DRB CASE ACTION LOG (SITE PLAN B.P.)

DRB Application No.: 04DRB-01012 (SBP)

Project # 1003524

Project Name: LANDS OF SPRINGER MATER.

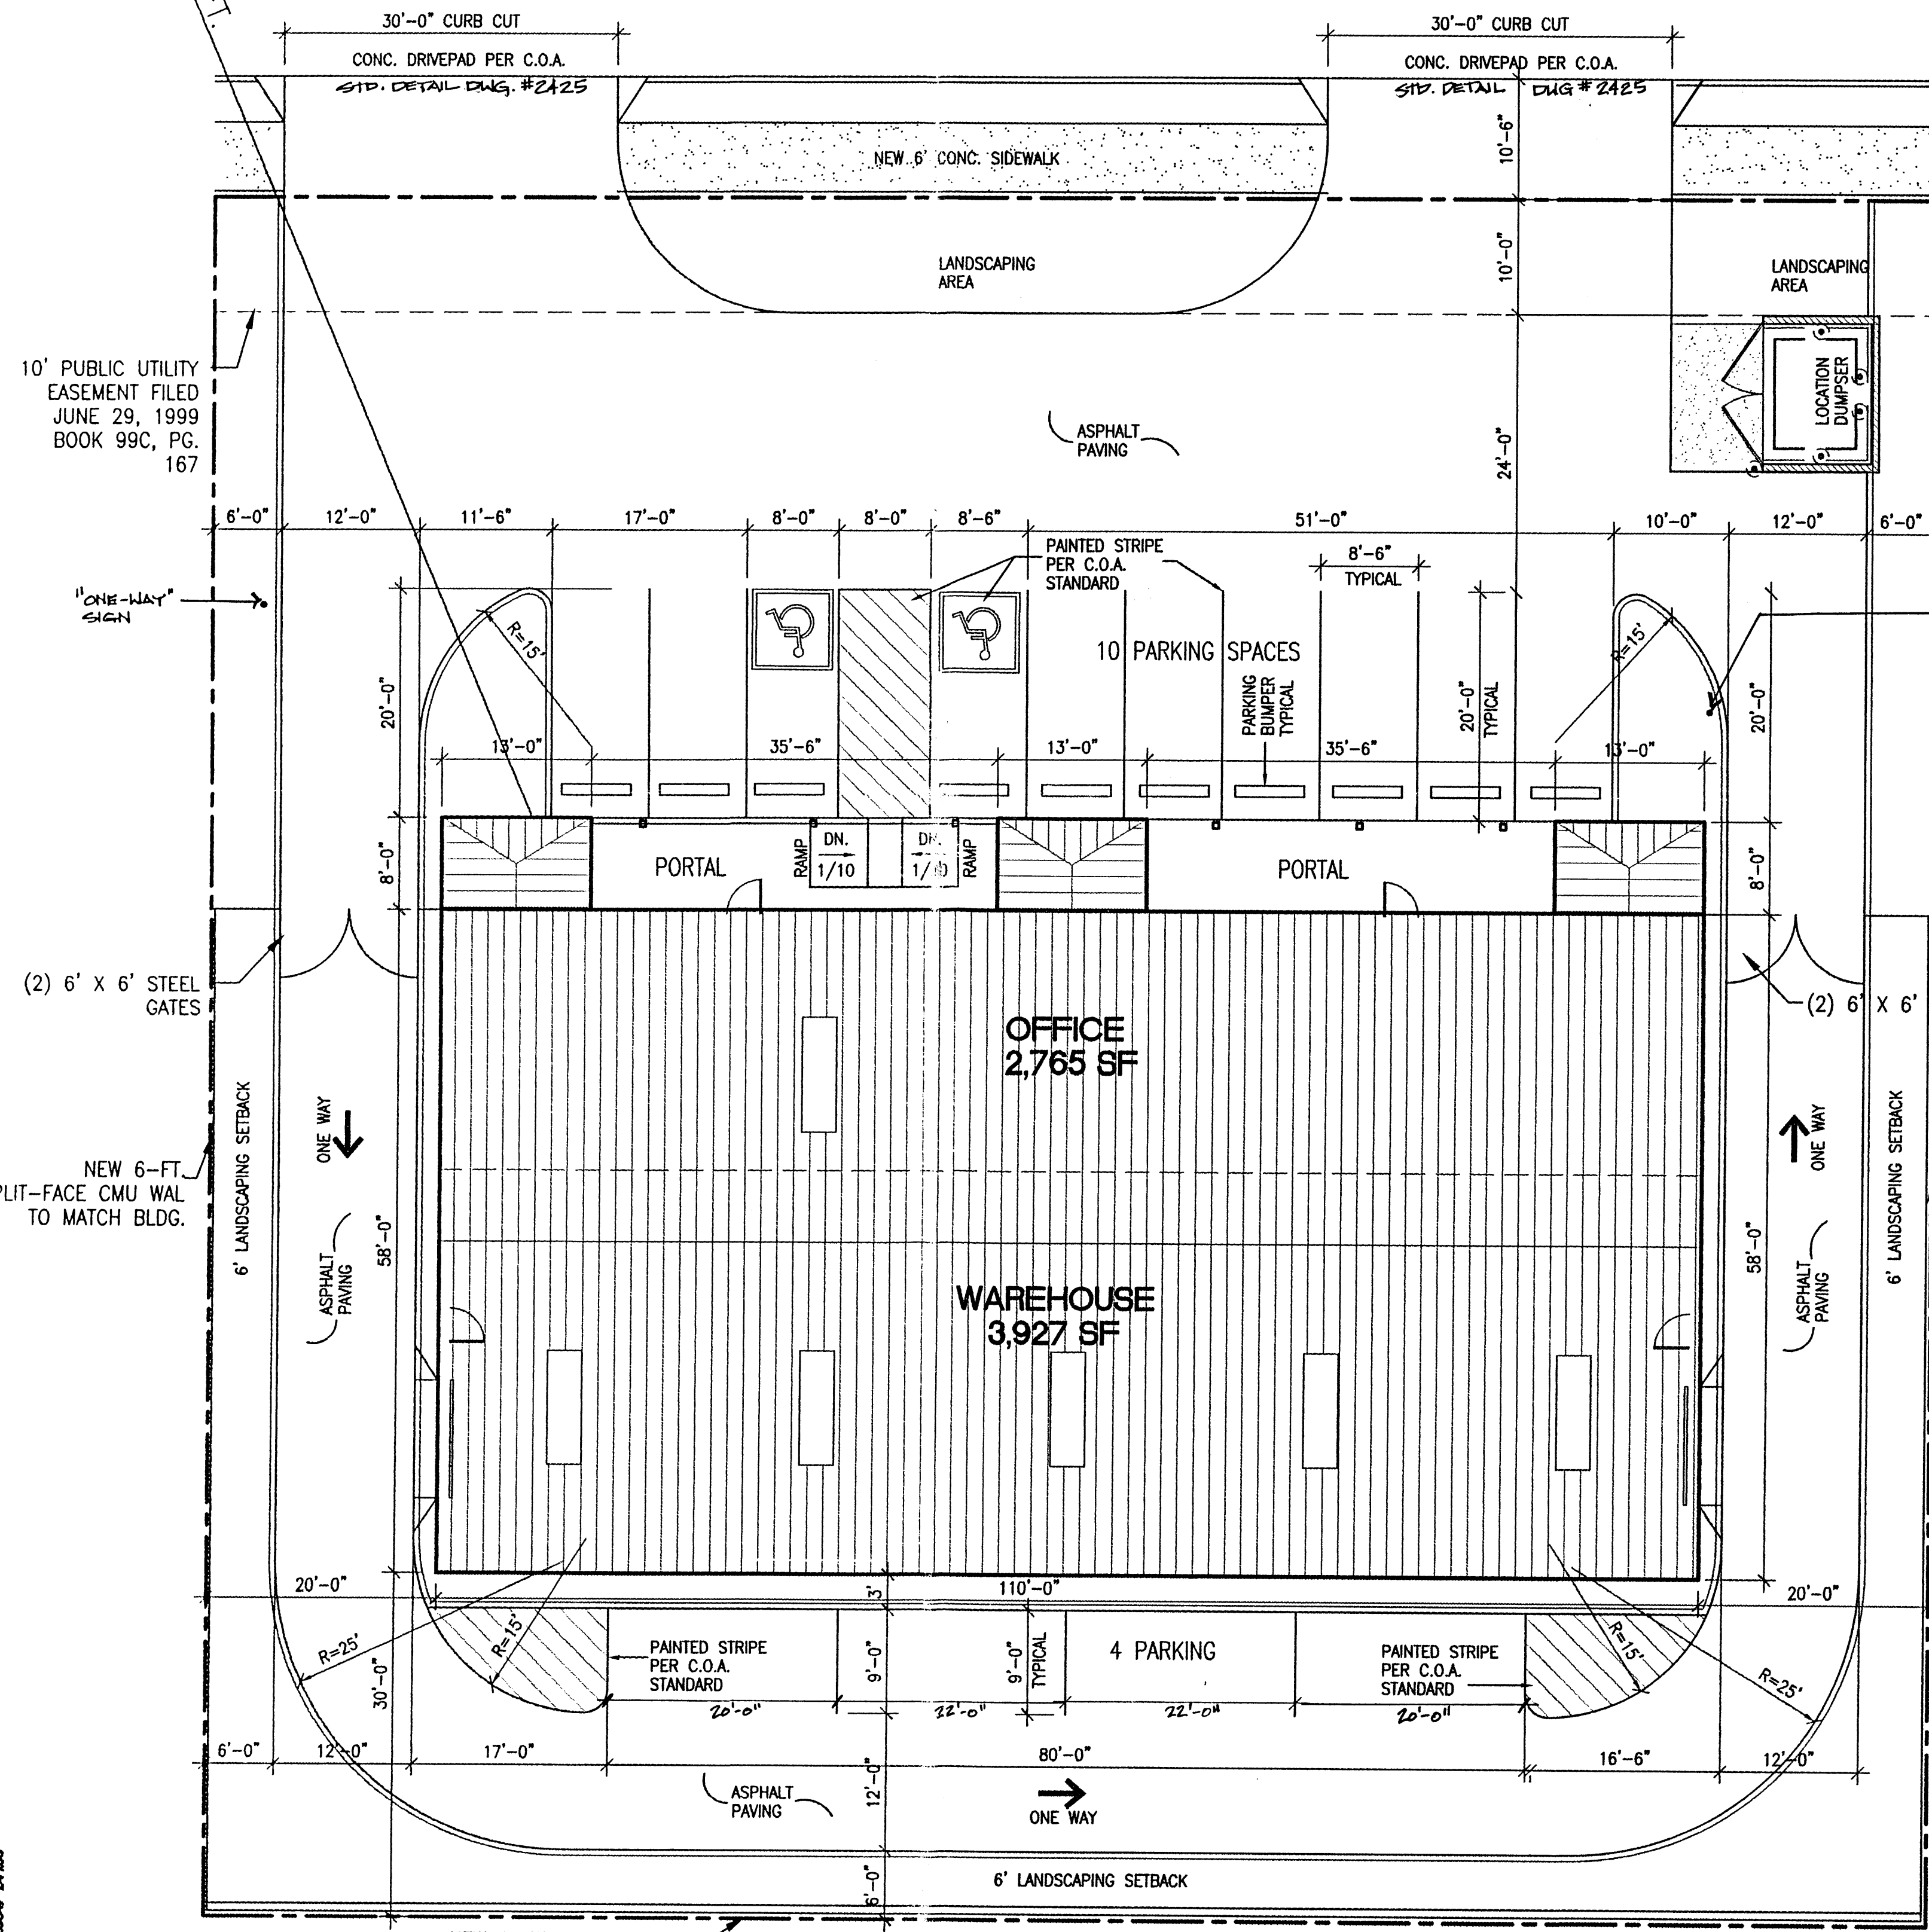
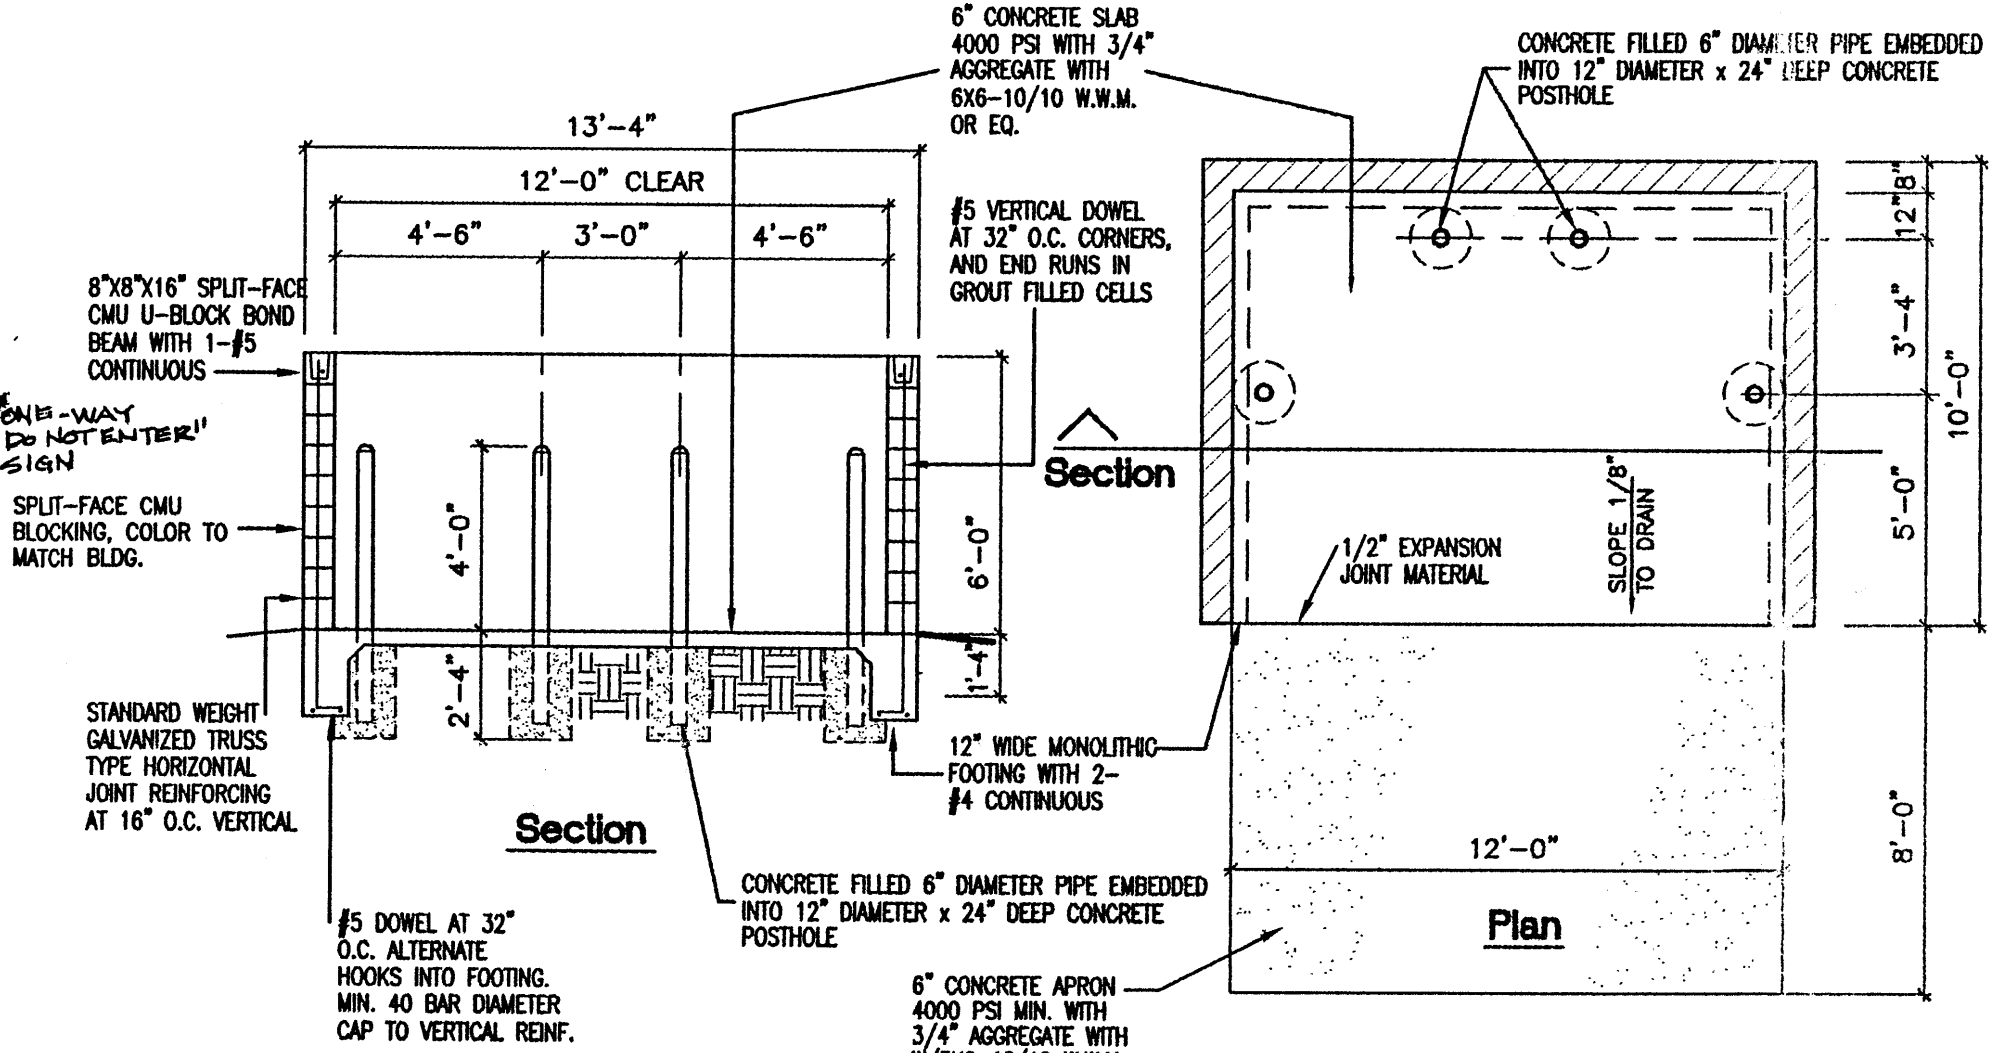
- TRANSPORTATION: (1) ONE-WAY SIGNS
- (2) CITY STD DRAW N² FOR CURB CUTS
- (3) PARALLEL INTERIOR PARKING SEALS 22'
- OK N/A
- 8-3-04

9. **Project # 1003524**
04DRB-01012 Minor-SiteDev-Plan
BldPermit
- RICK BENNETT ARCHITECTS agent(s) for WASHINGTON STREET INVESTMENTS request(s) the above action(s) for all or a portion of Lot(s) 17, Tract(s) B-1-A-1, ALAMEDA BUSINESS PARK, **LANDS OF SPRINGER BUILDING MATERIALS CORP.**, zoned SU-2, IP - EP, located on VISTA ALAMEDA NW, between PASEO ALAMEDA NW and ALAMEDA PARK DR NW containing approximately 1 acre(s). *[Deferred from 7/14/04]* (C-16) **SITE PLAN FOR BUILDING PERMIT WAS APPROVED WITH FINAL SIGN OFF DELEGATED TO TRANSPORTATION DEVELOPMENT FOR ONE- WAY SIGN, CITY STANDARD DRAWING NUMBER FOR CURB CUTS AND PARALLEL INTERIOR PARKING STALLS 22 FEET AND PLANNING FOR SIGNAGE ON BUILDING.**
